RFI

RFI #: 80
Date: 3/20/2012
Job: EB-02 Keller Springs Lofts
Phone: 877-777-5115

Subject: Elevation conflict with floors

SHEET NUMBER
3.3

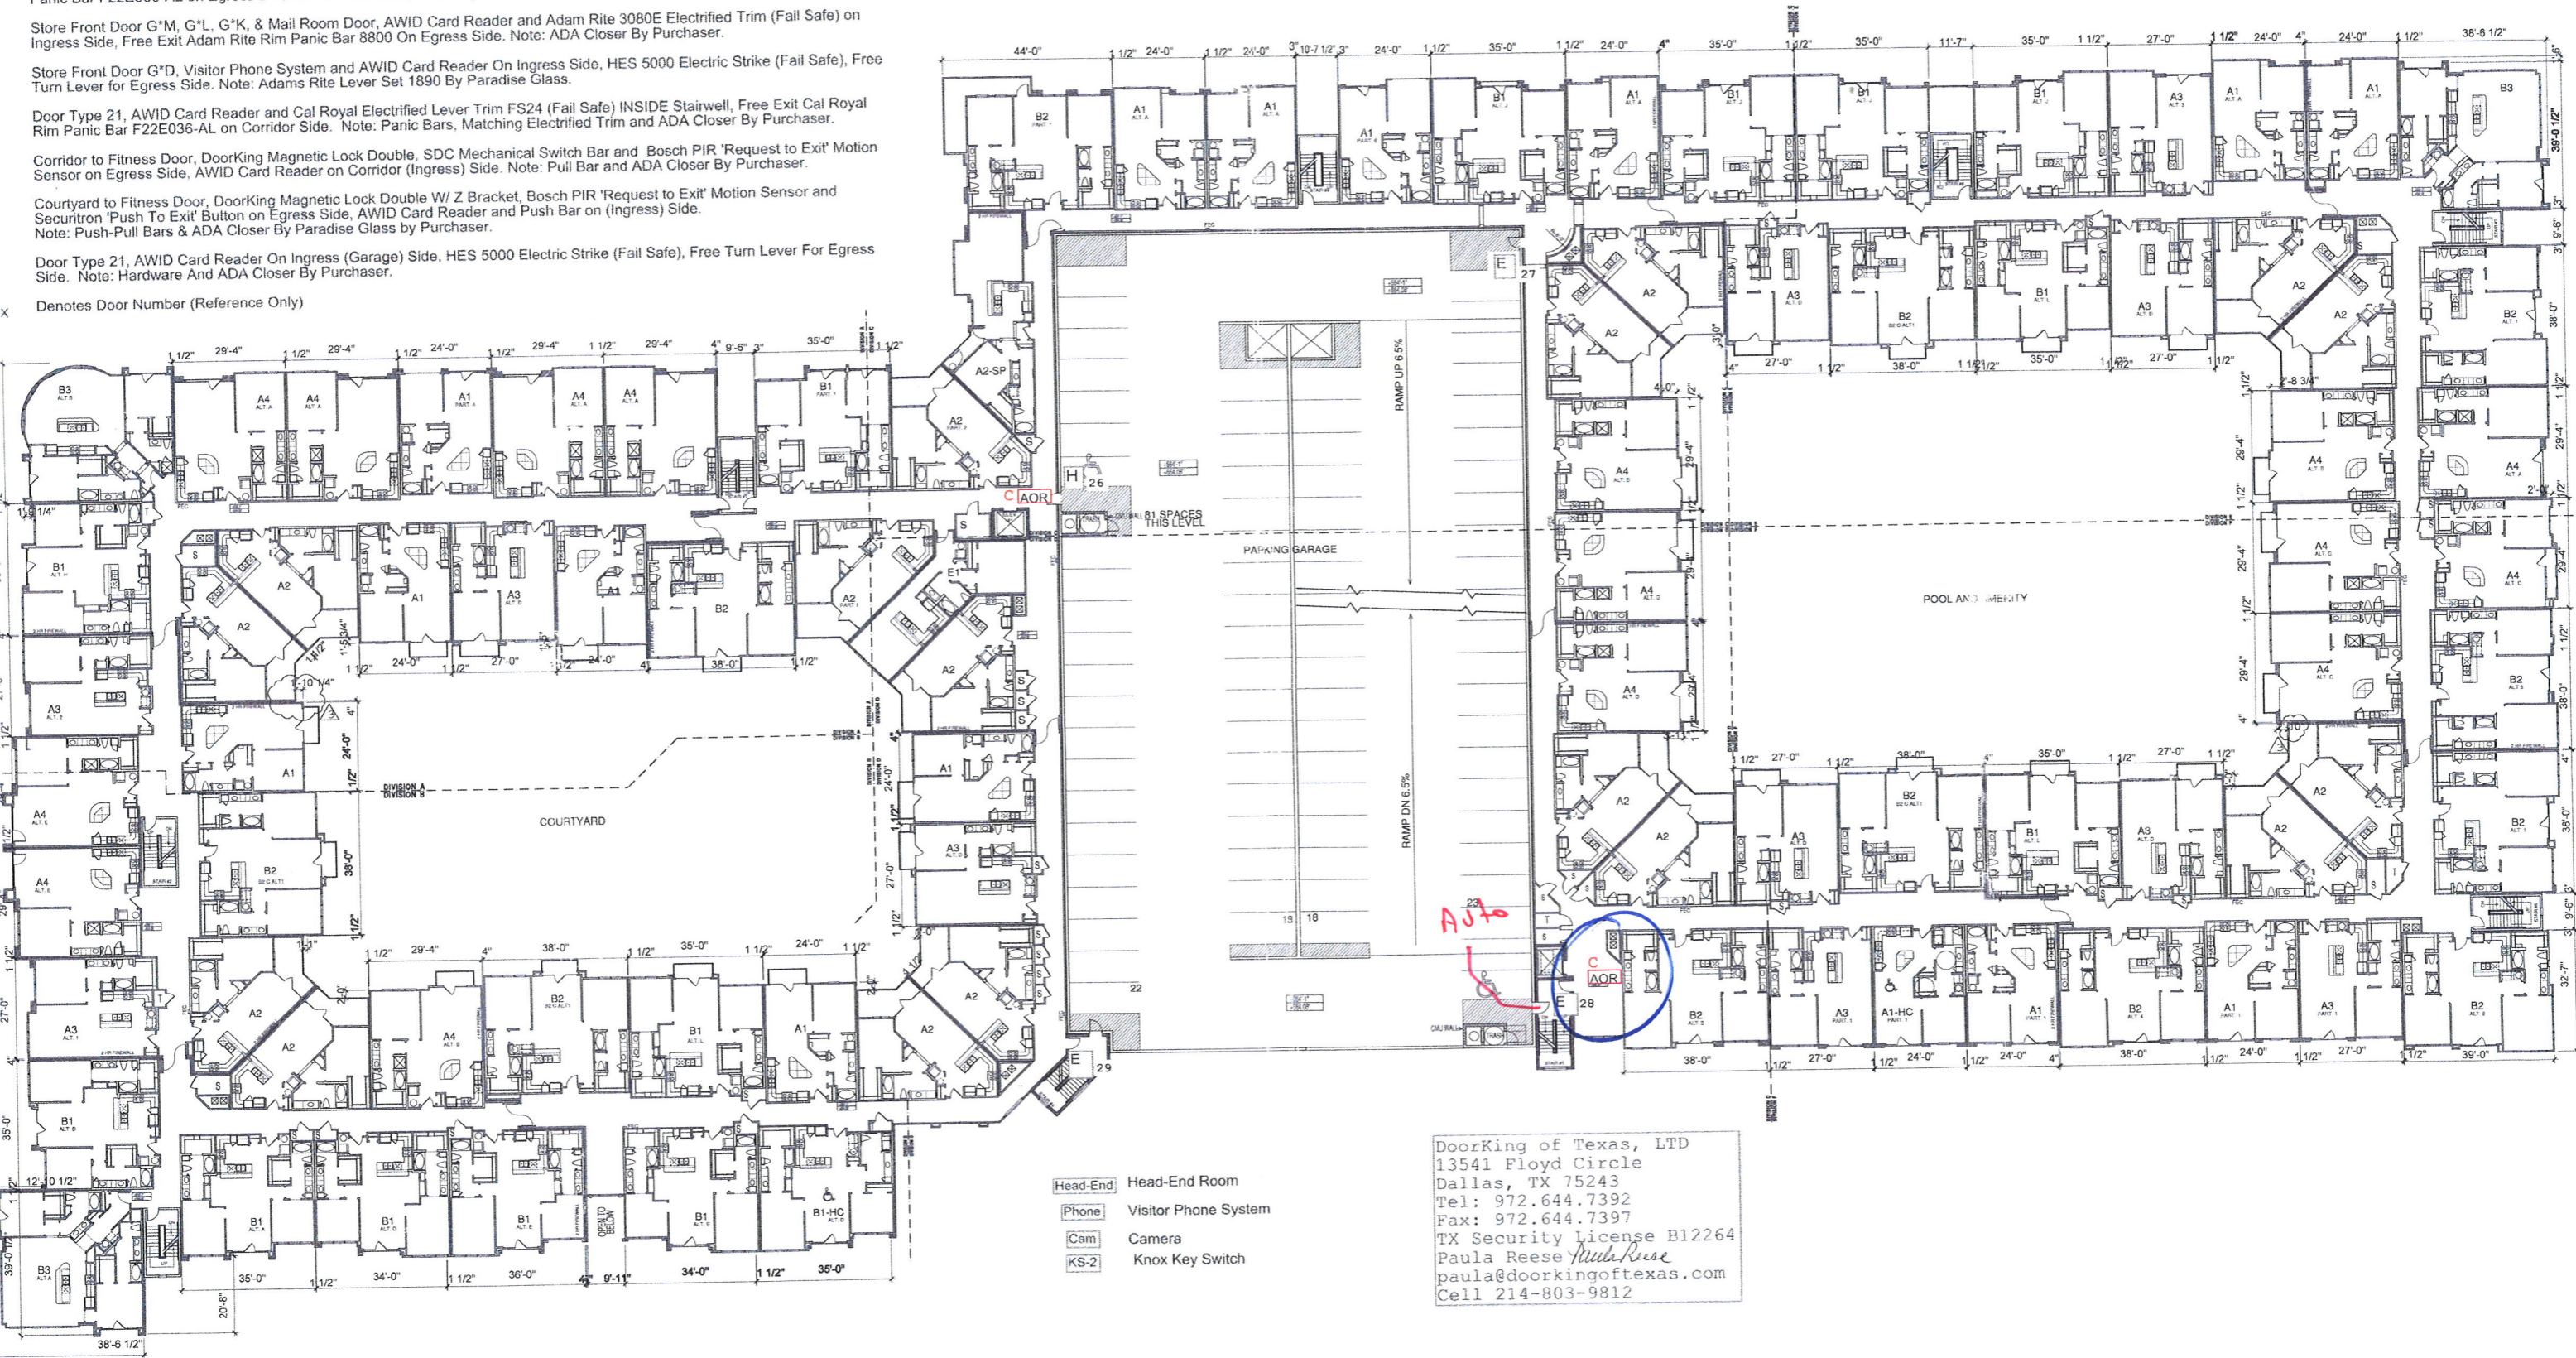
Drawing: 3.1, 3.2, 3.3, 3.4
Cost Impact: None

Thank you for addressing RFI #48. Your answer to #48 has us installing an additional 1x to the bottom plate to achieve specified elevations at 2nd 3rd and 4th floors around the parking garage. We do agree with adding the 1x to 2nd and 3rd floor bottom plates, but we think it should be to the entire 2nd and 3rd floors. The problem that we resolved around the garage is still present at the other stairwells. Here is a list of potential problems with installing the 1x to only parts of the floor

- 1 we will have step downs in the corridor ceilings
- 2 we will still have elevation problems at stairwell #s 1-2-3-5-7-8
- 3 floor plate differences at exterior elevations
- 4 the ramping of the floors (that you have addressed)
- 5 we will have to add a 1x to top of 4th to all areas not raised or field cut all of the studs in your shaded area to achieve proper roof truss bearing.

In summary we think that we should install the 1x to all of 2nd and 3rd floor bottom plates. Erik this was previously discussed with the Project Manager David Gallagher, the Project Super Brian Peterson and with you and agreed upon by all parties.

Response: BGO agrees and has no exception to this change.
